Date: 09/01/2023

Re: **Framing Issue**
Location: 1425 Baptist Grove Rd. (Fuquay-Varina, NC)
JDS Project No.: RDU2307952
Date of Inspection: 9/1/23

SECOND FLOOR FRAMING PLAN

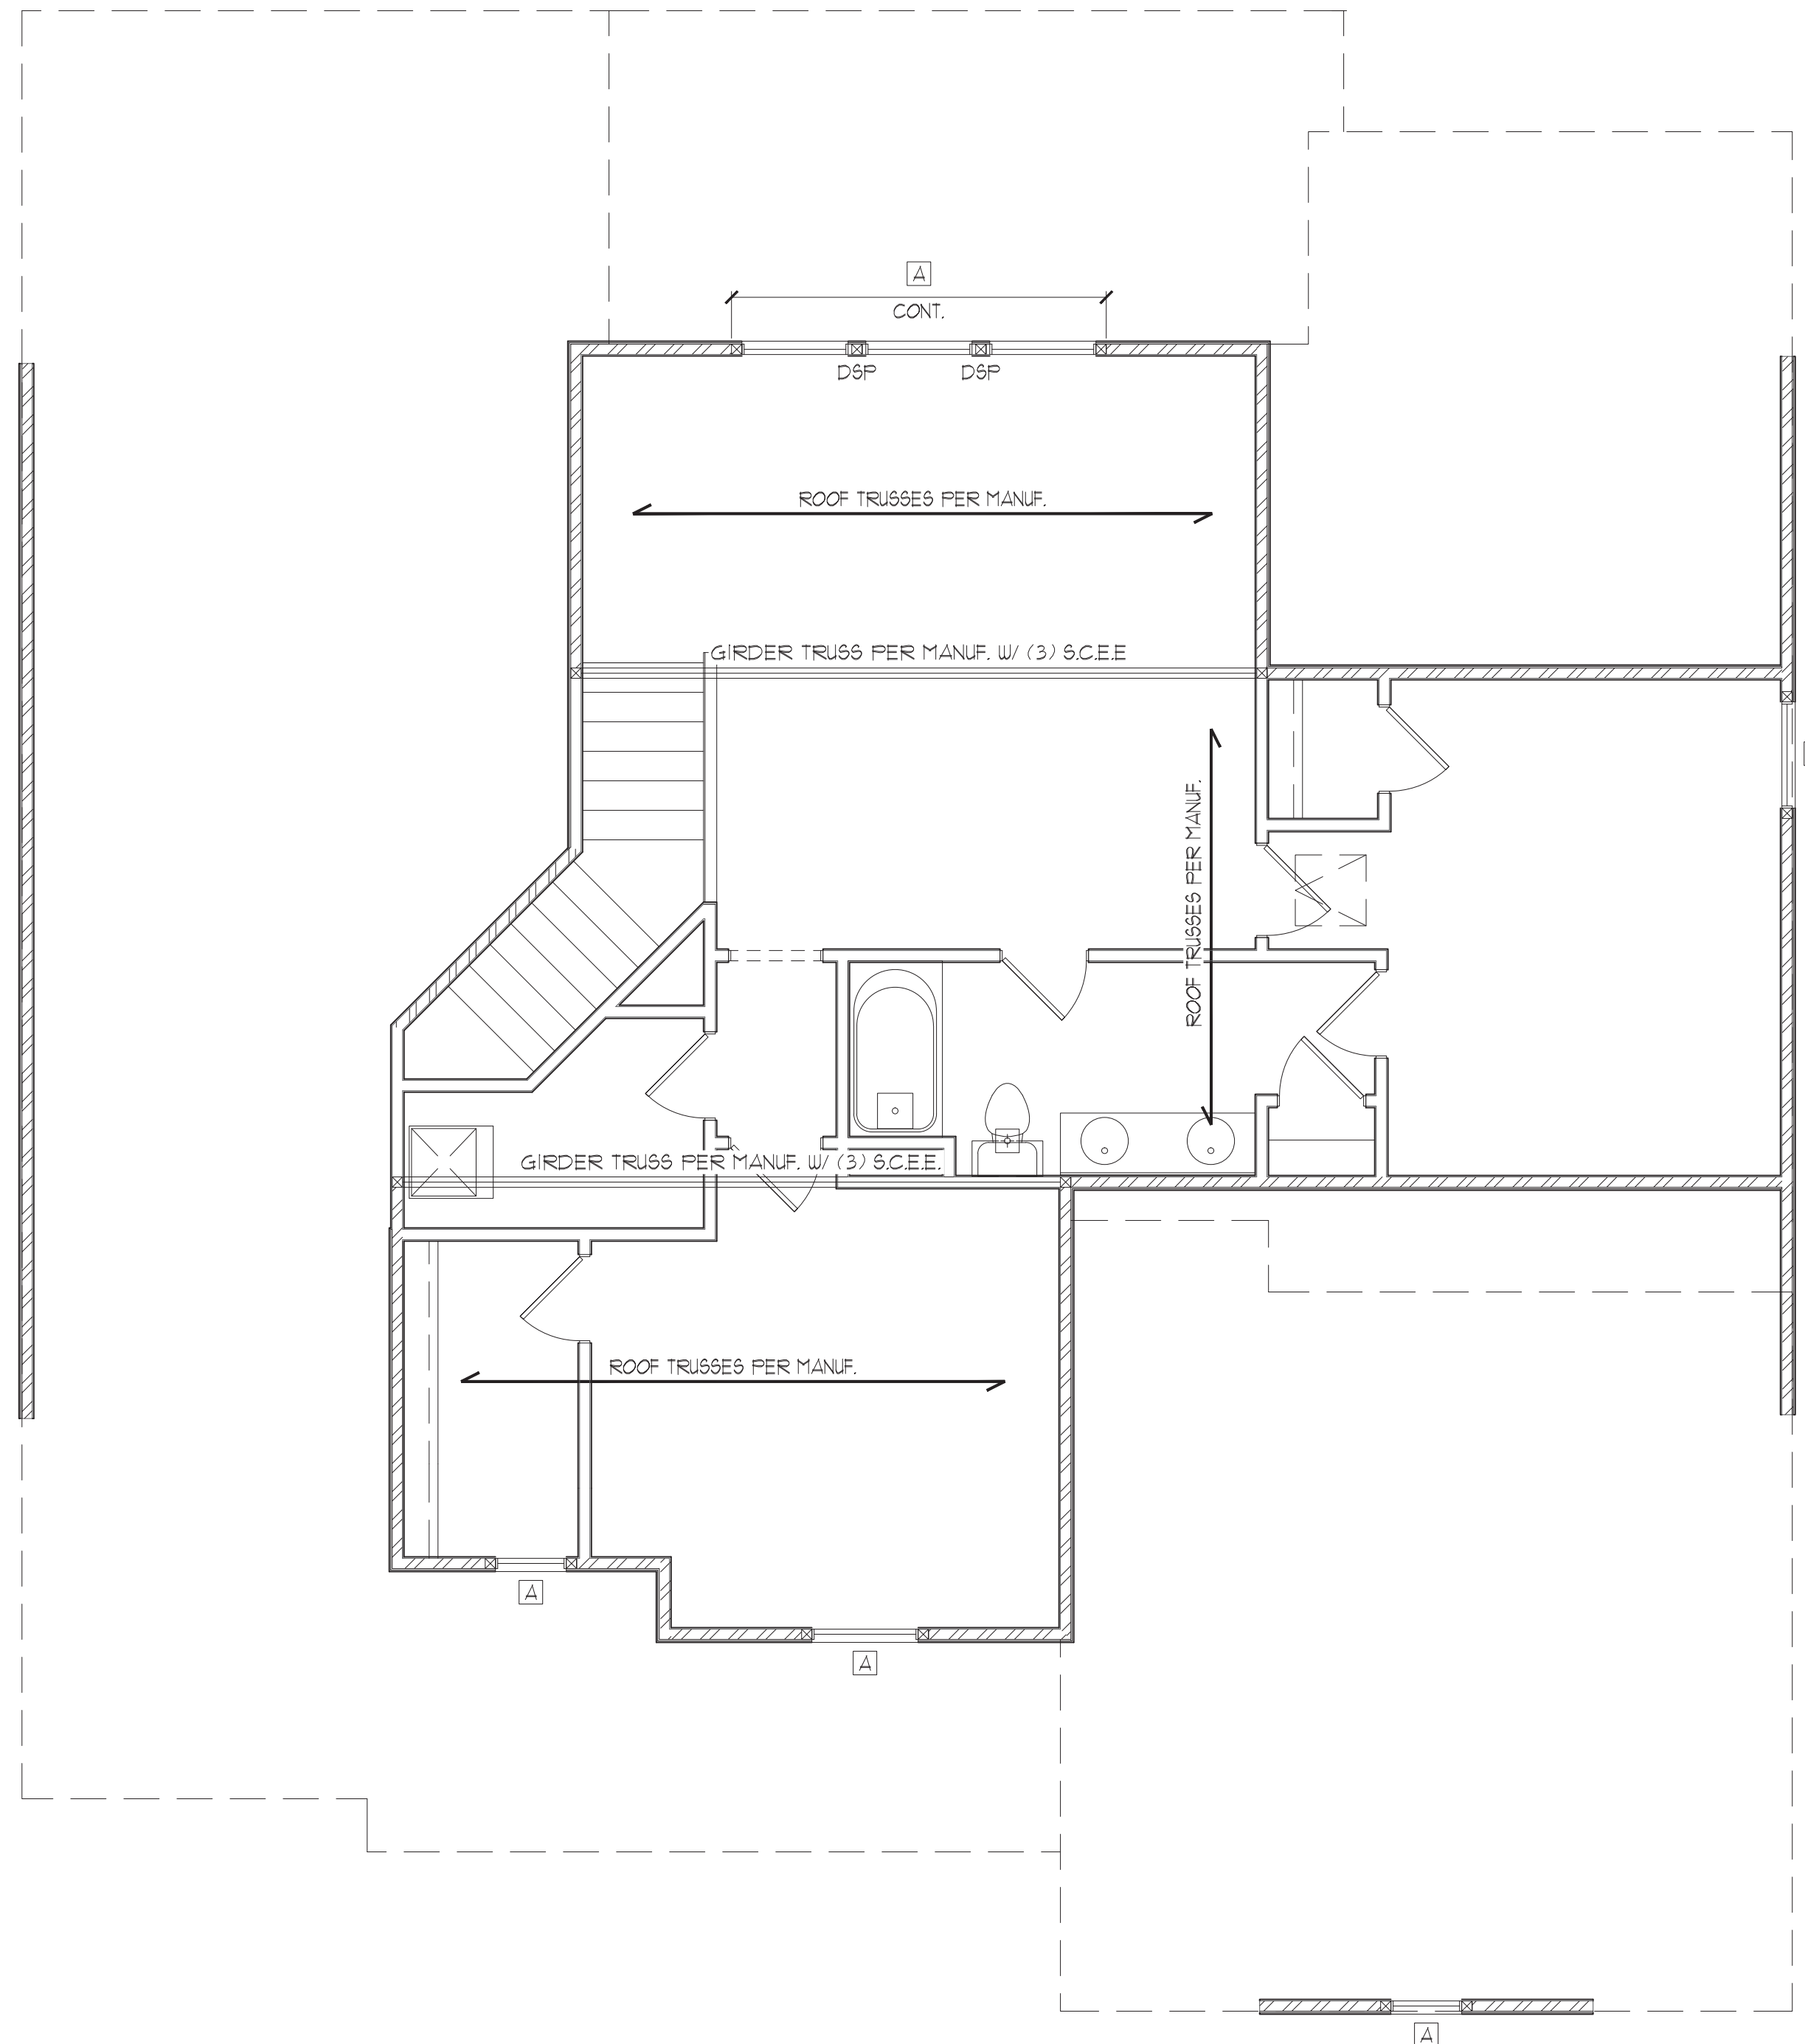
The client has requested evaluation of the steel I beam bearing on both the jack stud columns and the headers at both the front and rear bearing end instead of bearing solely on the jack stud columns as specified in the plans.

Based on our onsite observation and review the current bearing conditions are adequate for the calculated loads at both the noted bearing locations. No further action is required.
